From: Jeff Watson
Sent: Wednesday, August 21, 2013 2:27 PM
To: 'Cruse & Associates'
Subject: RE: BL-13-00006 Rinehart

BL-13-00006 Rinehart

Kittitas County Community Development Services has issued conditional approval for the above Boundary Line Adjustment Application. See attached file. Copies of the original CPA and Comment Letters have been sent to all three applicants, please feel free to contact me if you have additional concerns or questions.

PROPOSED
 ACCESS LOCATION

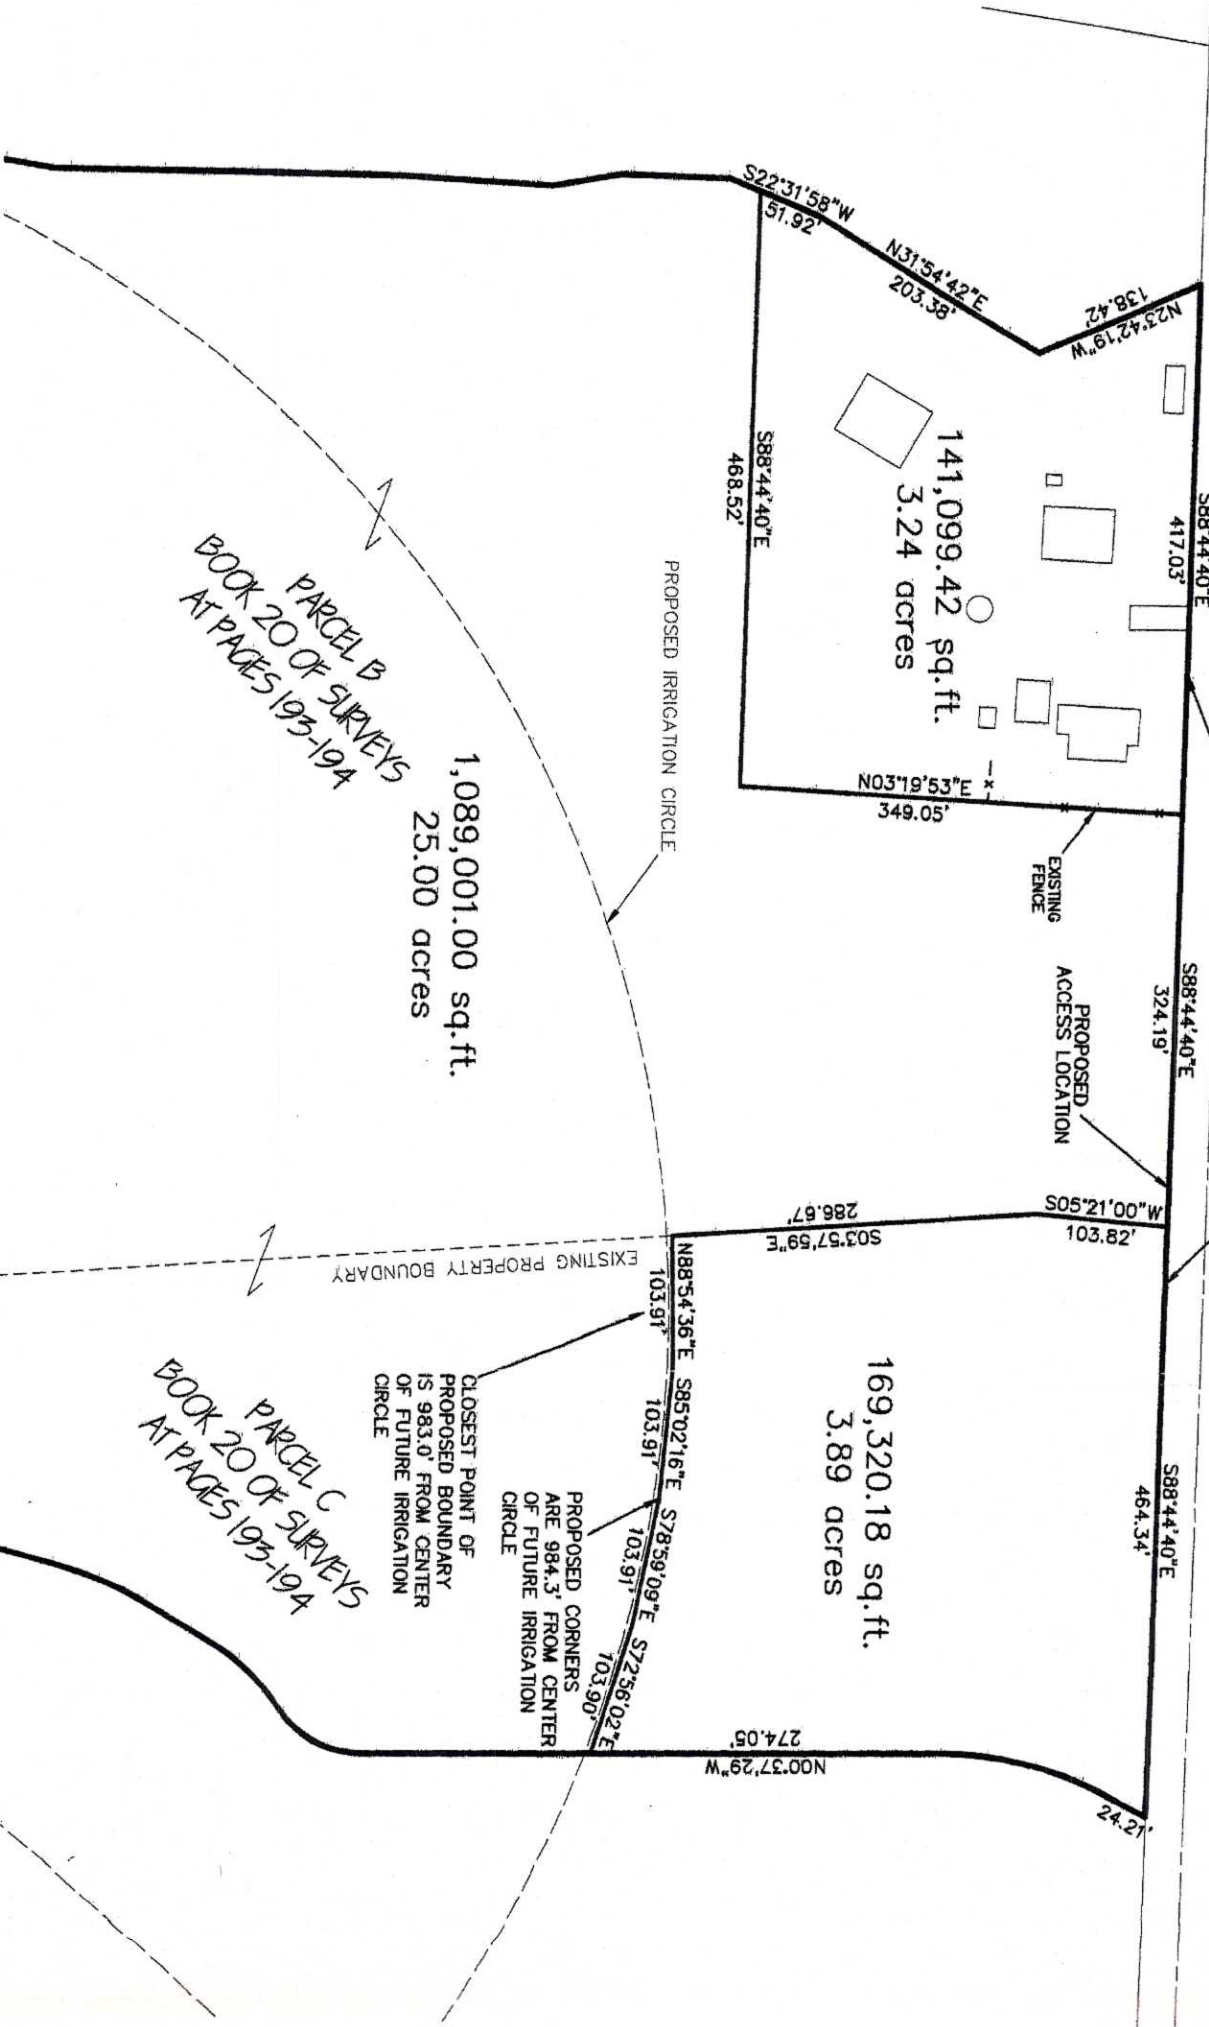
It is only 80ft approx from the other access so it does not meet spacing requirements (300ft). It also may not meet sight distance requirements, but I can't tell that for sure without a site visit. The existing driveway is located at the crest of the hill and may have been put in that location for safety reasons.

A variance is a possibility, but without a really good reason I don't foresee this being approved. I do not make that decision though.

Rinehart has reviewed the sight distance issue and would like to adjust to the attached configuration. Please review and let me know your concerns.
